NORTH

LAND DESCRIPTION:

LOT 2, ROCKY MOUNTAIN INDUSTRIAL PARK FILING NO. 1A,
EL PASO COUNTY, COLORADO AS SHOWN ON THE SUBDIVISION
PLAT THEREOF RECORDED UNDER RECEPTION NO. 209712968
OF THE EL PASO COUNTY RECORDS.

SITE DEVELOPMENT PLAN & SITE DATA
SCALE: AS NOTED
Sheet Number:
SDP-1
OF 2 SHEETS

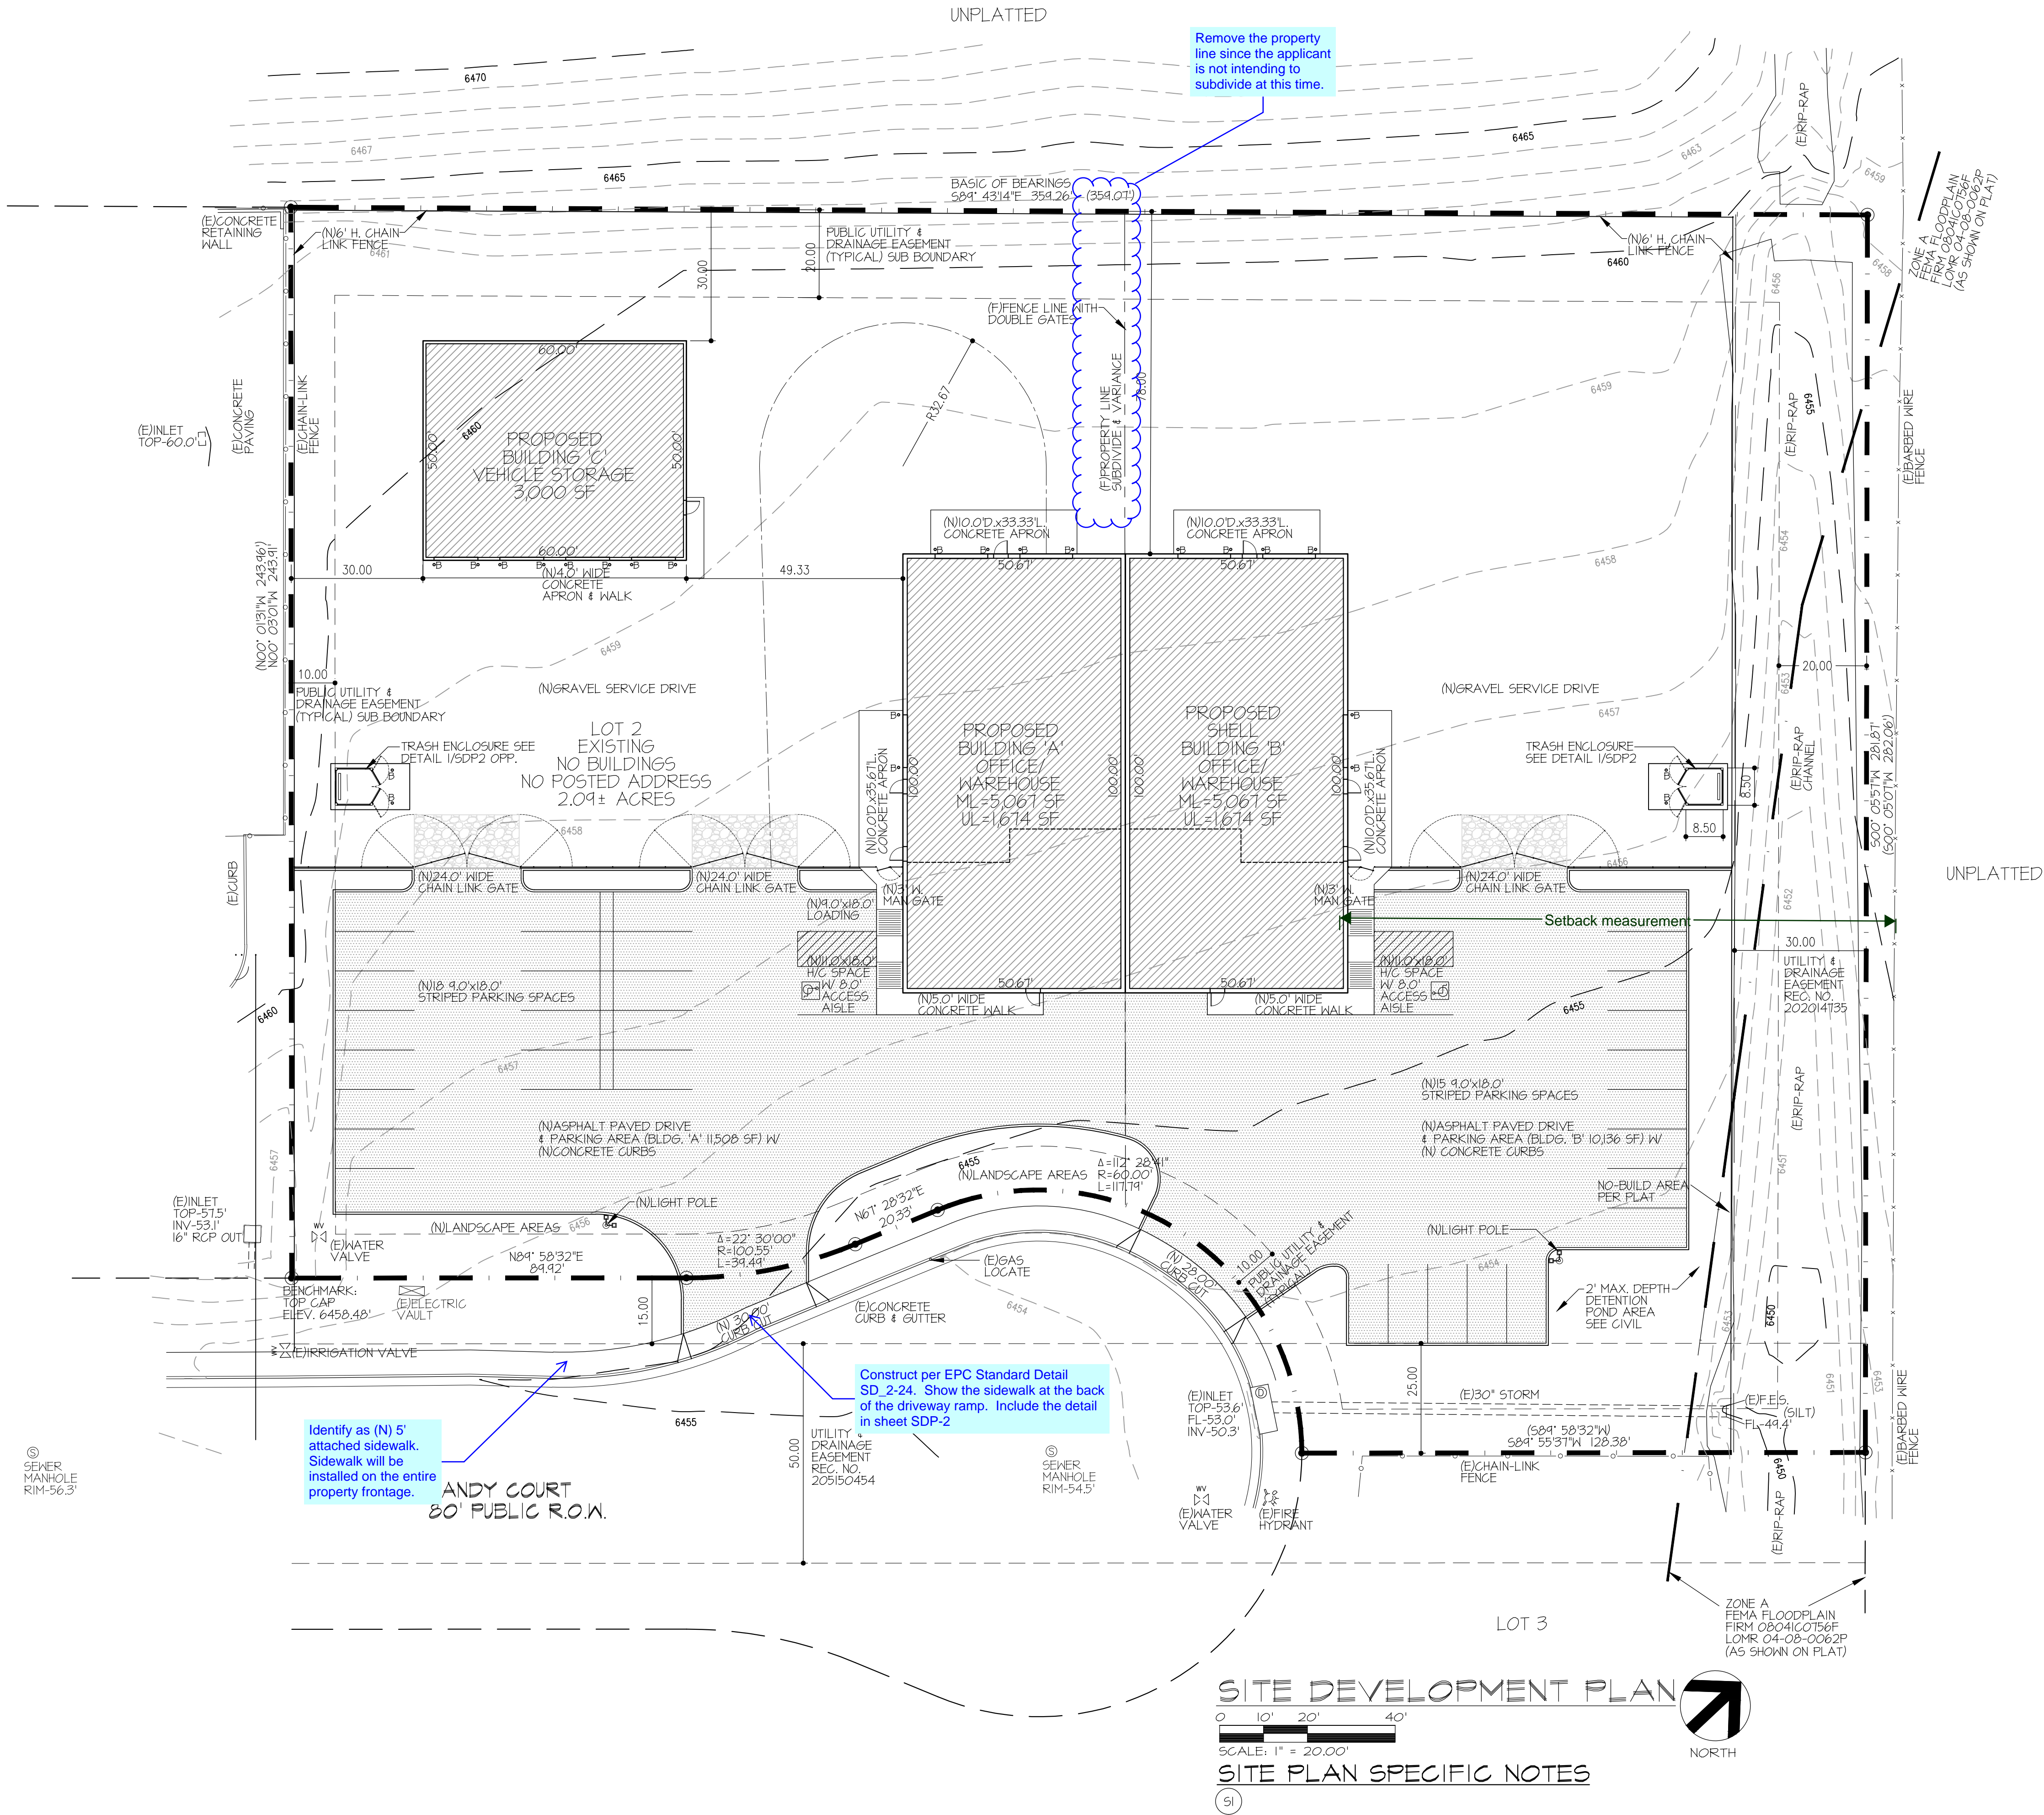
This needs more
detail.

This needs more detail.
